Planning and Regulatory. G.Mansfield
Reference: PB2016/10434 & PB 2016/10481
Phone: 02 4974 2767

29 November 2016

**NOTIFICATION OF DEVELOPMENT APPLICATION MAYFIELD WEST
RESOURCE RECOVERY FACILITY (SSD 7698)**

**Site layout**  
 Recycling Facility, Mayfield West  
 Figure 2

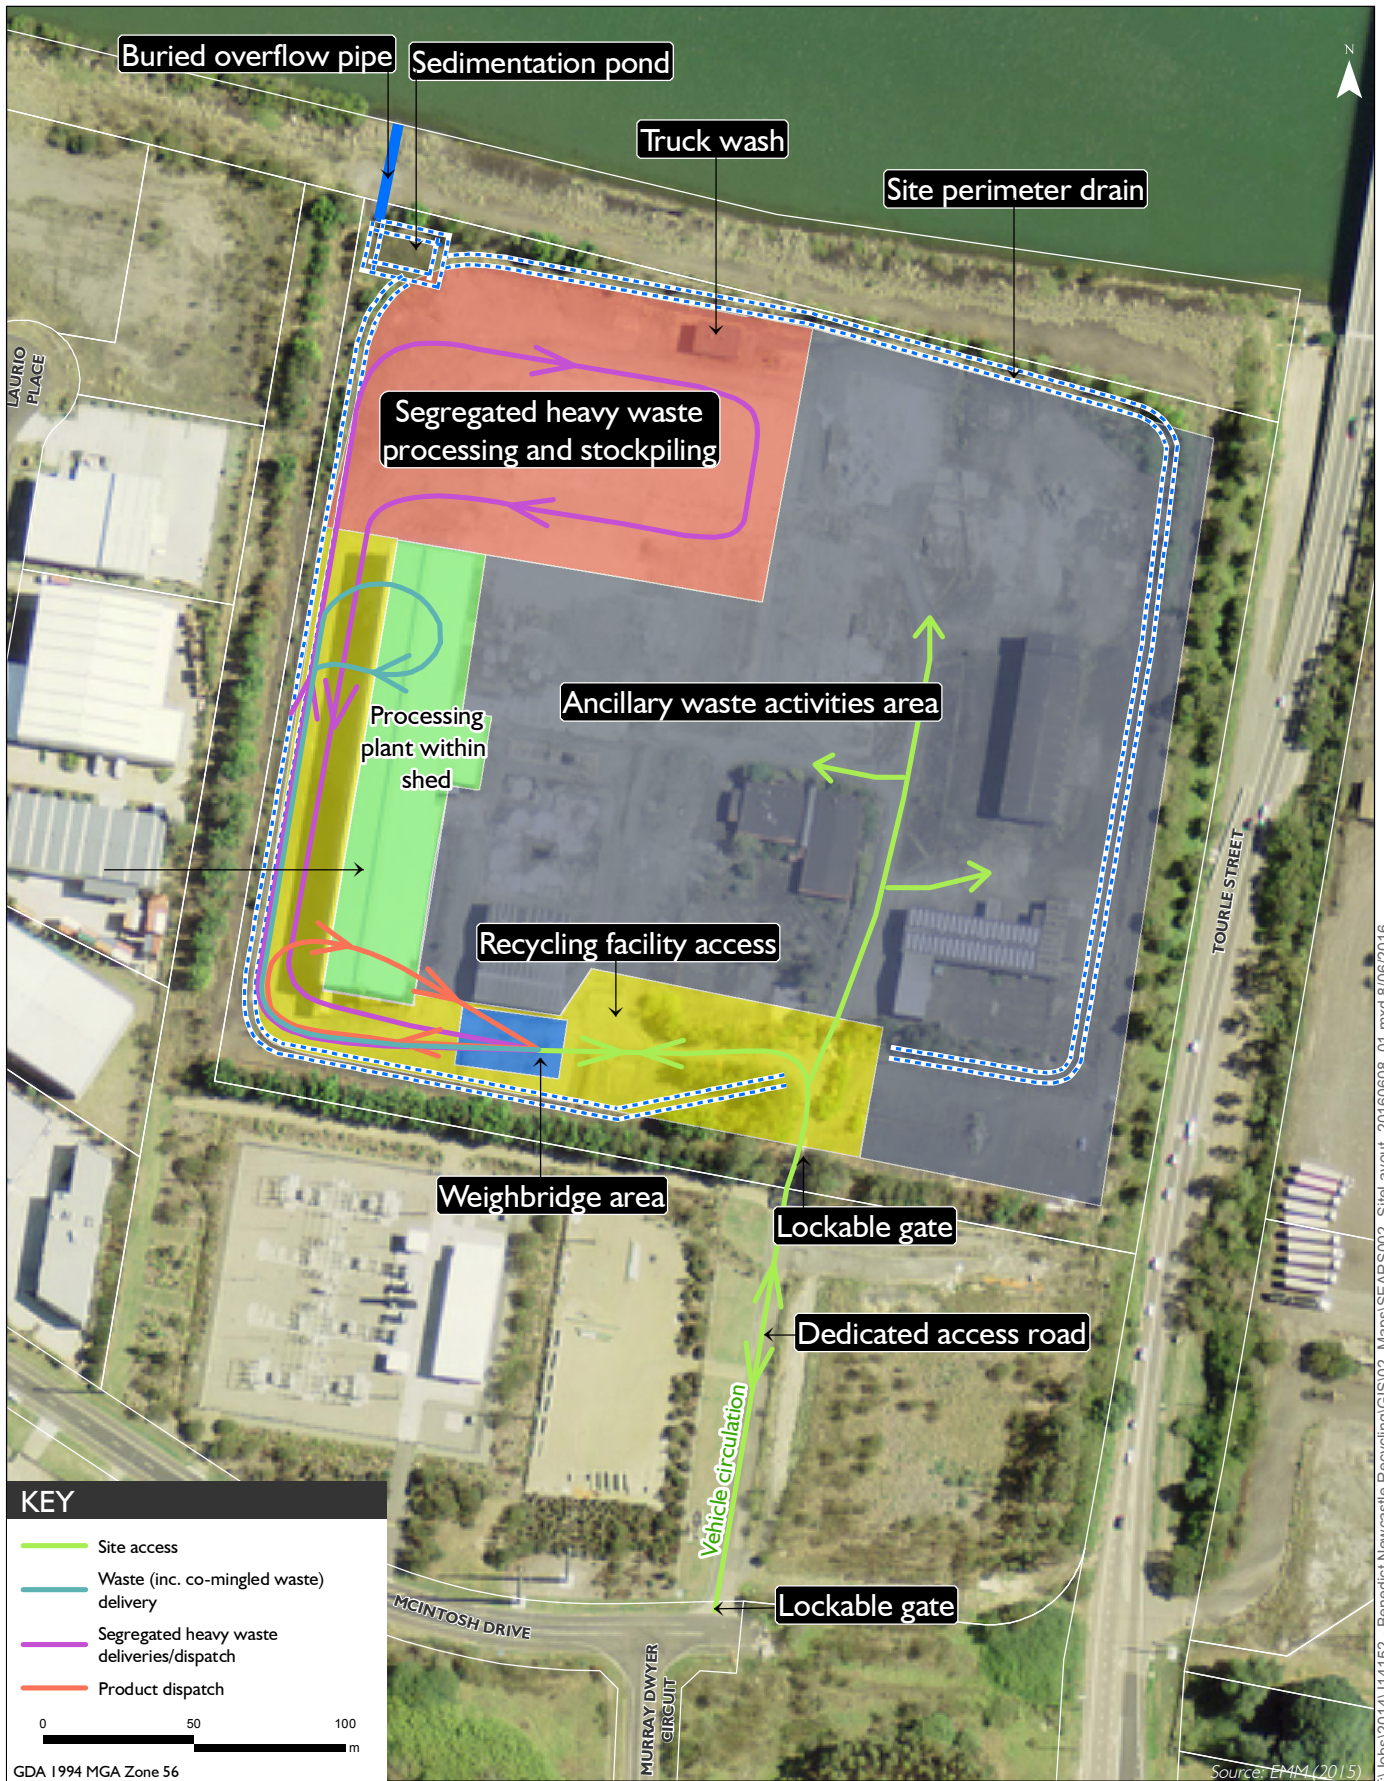
The current development proposes to provide 19 spaces for employees and visitors in the vicinity of the weighbridge area. Contrary to the terms of the SEARS the application has not been supported by '*detailed plans of the proposed layout of the internal road network and parking on site in accordance with the relevant Australian Standards.*'

Based on the conceptual diagrams of the relocated car parking facilities, concern is raised at the increased potential for conflict between and light and heavy vehicles. It is recommended that the parking spaces be retained in the existing car park.
